From: Gregg, Robert <Robert.Gregg@lancashire.gov.uk>
Sent: 05 December 2018 15:02
To: Robert Major
Cc: planning; LHS Customer Service
Subject: APP. 3/2018/1056 - PLOT 9 HARE HILL CROFT, CHATBURN OLD ROAD, CHATBURN

Non-material amendment from planning permission 3/2016/0748 to convert garage in to a playroom.

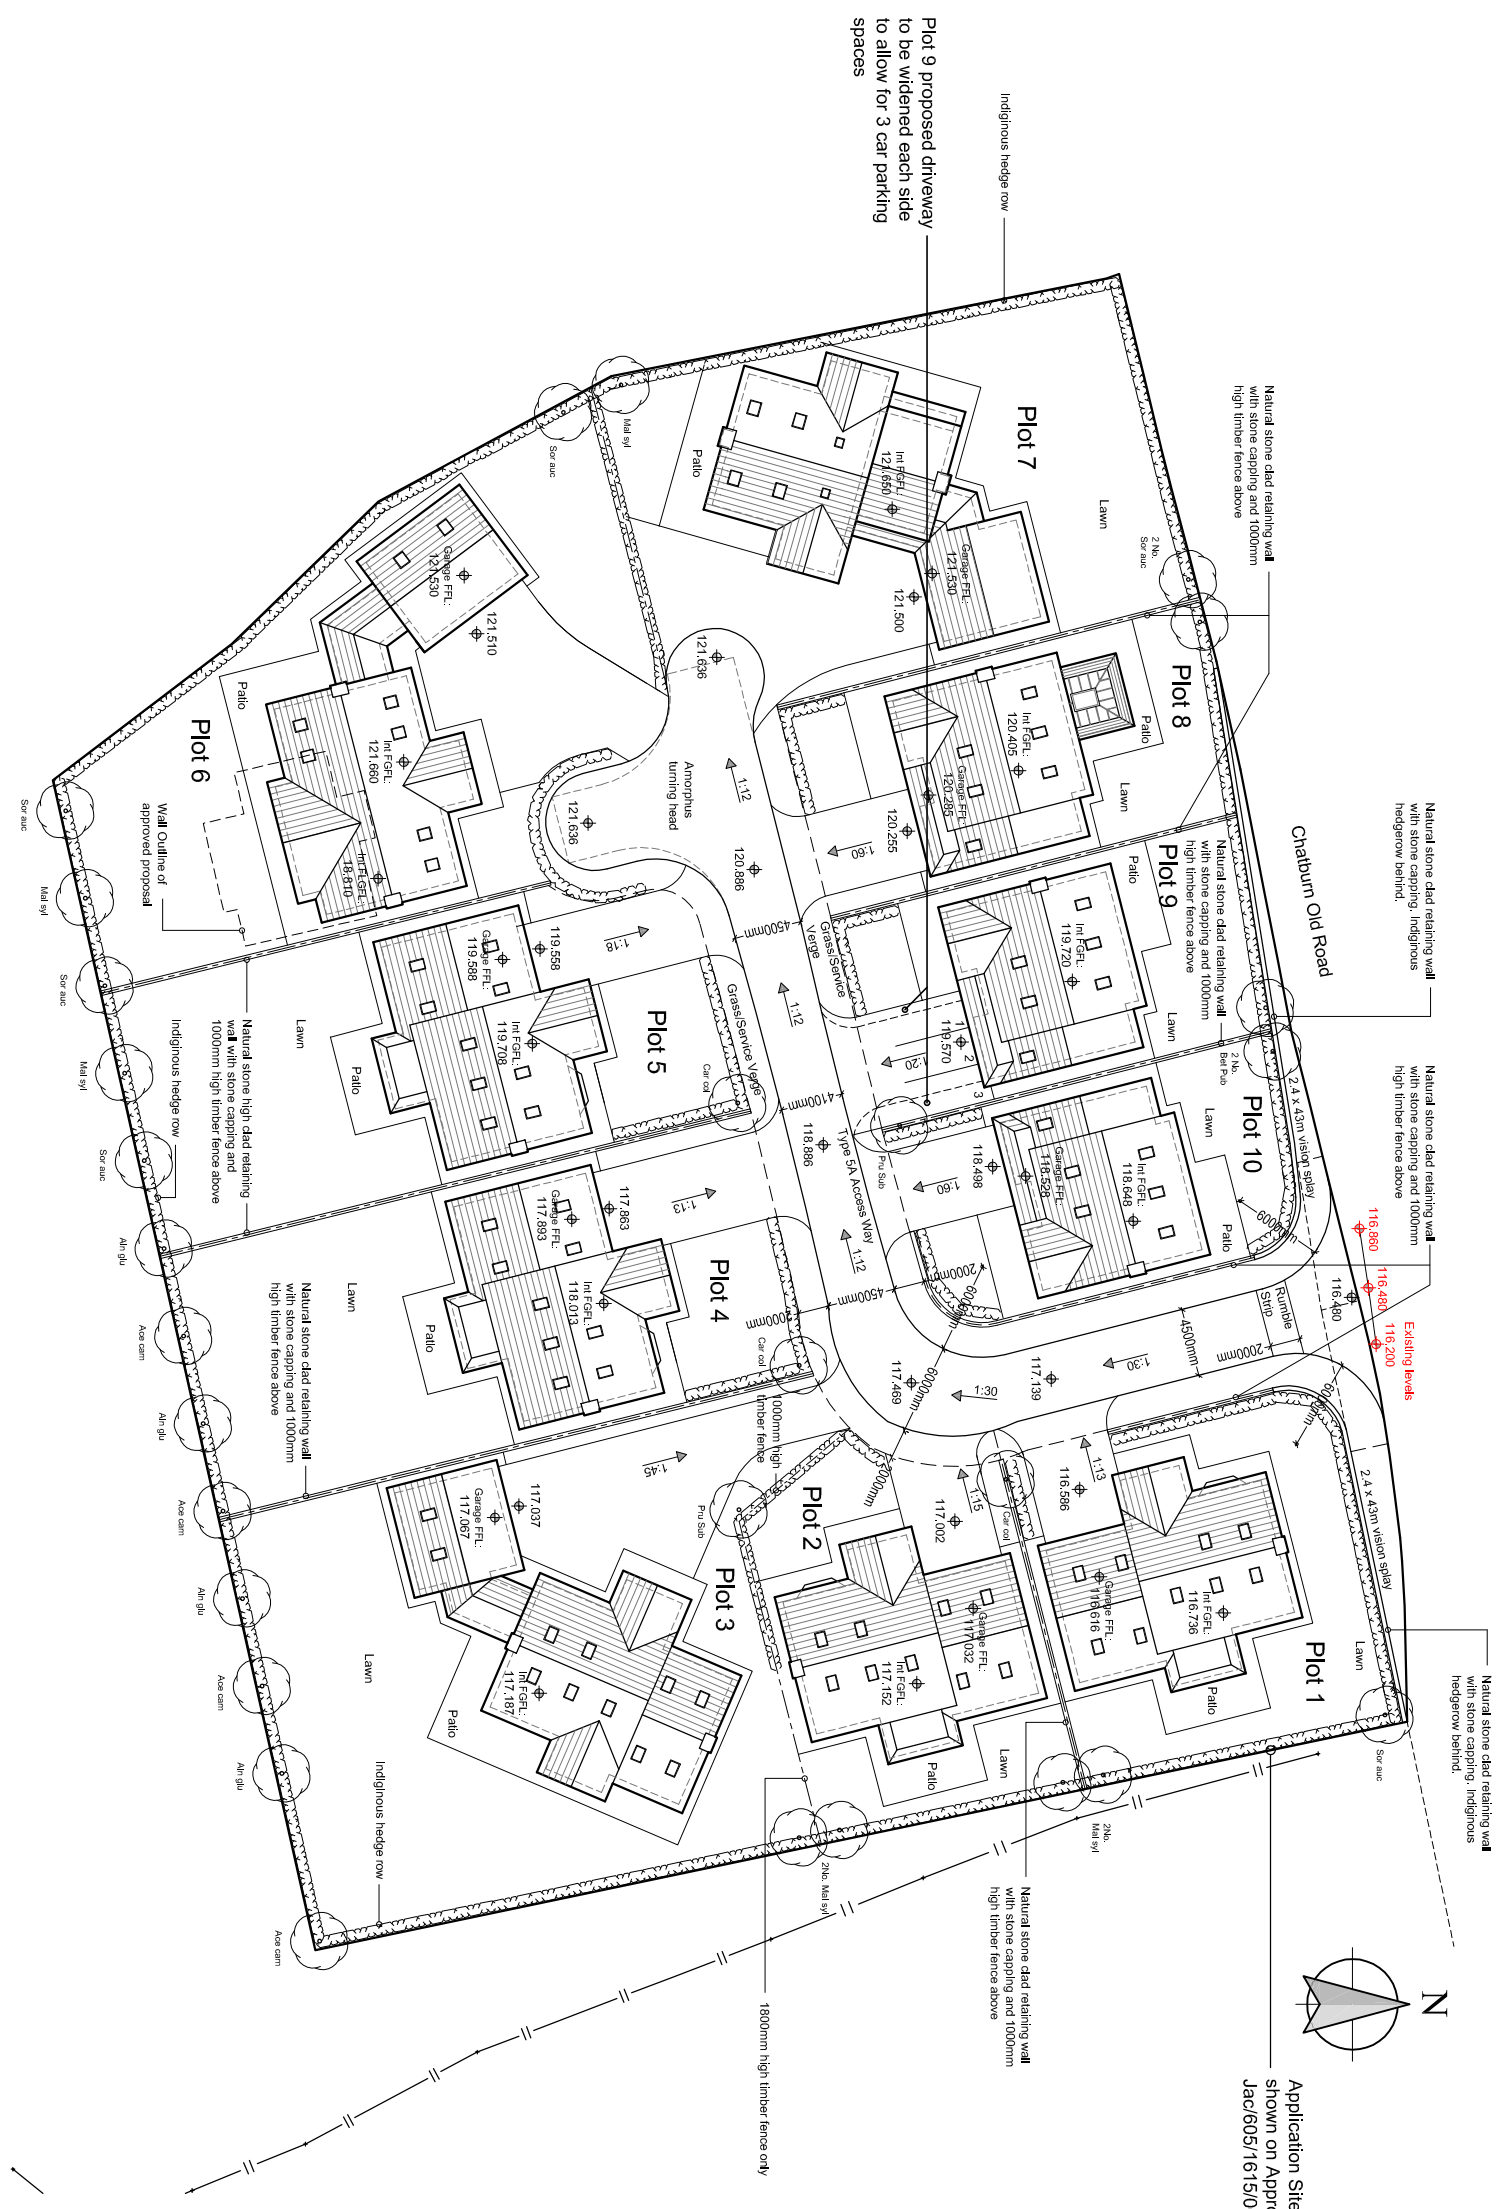
The submitted proposed site plan indicates the driveway will be extended to an overall width of 7.5m.

The driveway would need an overall width of at least 8.2m in order for the driveway to provide enough space to park 3 cars while also providing enough space to be able to walk to the front door of the dwelling.

There is also a 2m grass service strip which runs parallel with the dwelling, therefore the construction of the extended driveway sited within the 2m service strip to the entrance of the driveway would need to be done so under section 184 of the highway act 1980.

I would ask that the plans be revised.
